Subject: Planning application

I have studied the plans for the King's Cocktail Bar 03/2021/0172 and wanted to clarify some points.

The Kings, Clitheroe

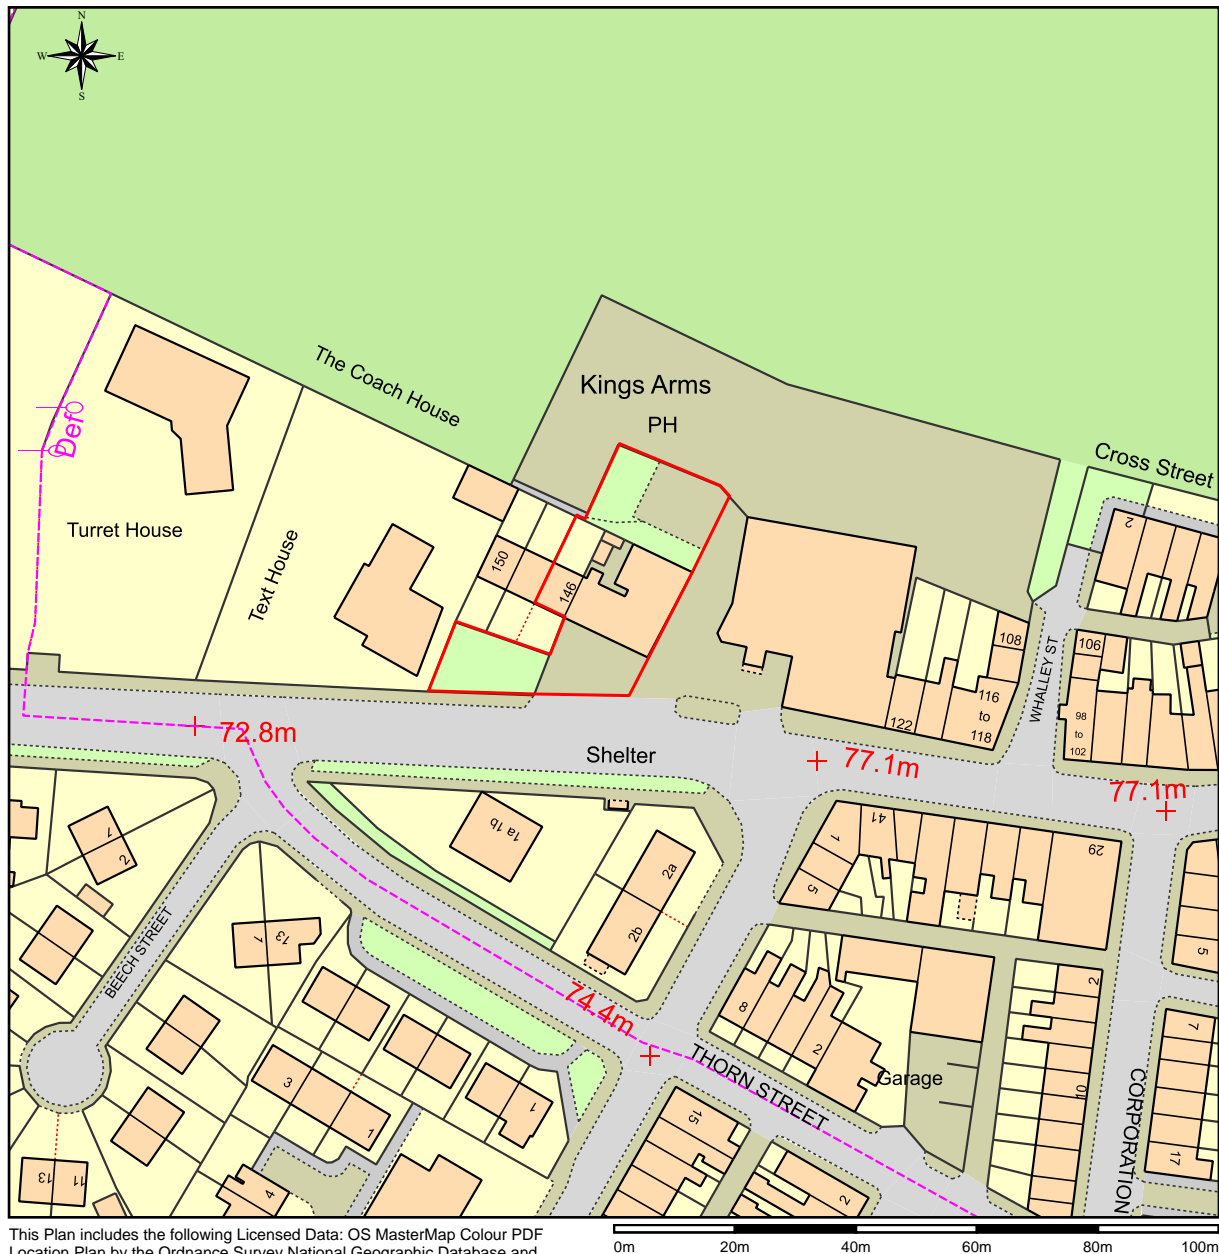
Secondly the change relies on sufficient parking to cope with the change of the flat and plans highlight the parking available. However the parking has easements which reduce the parking capacity. Also the developer has given our solicitor notice that they intend to change the car parks use and alter the access rights albeit unlawfully.

While this is a civil matter, the changes which will no doubt be passed. However this should be conditional upon no further change of use of the car parks at the front or rear and no alterations to existing rights of access. It's important that parking space is accurately represented to the council.
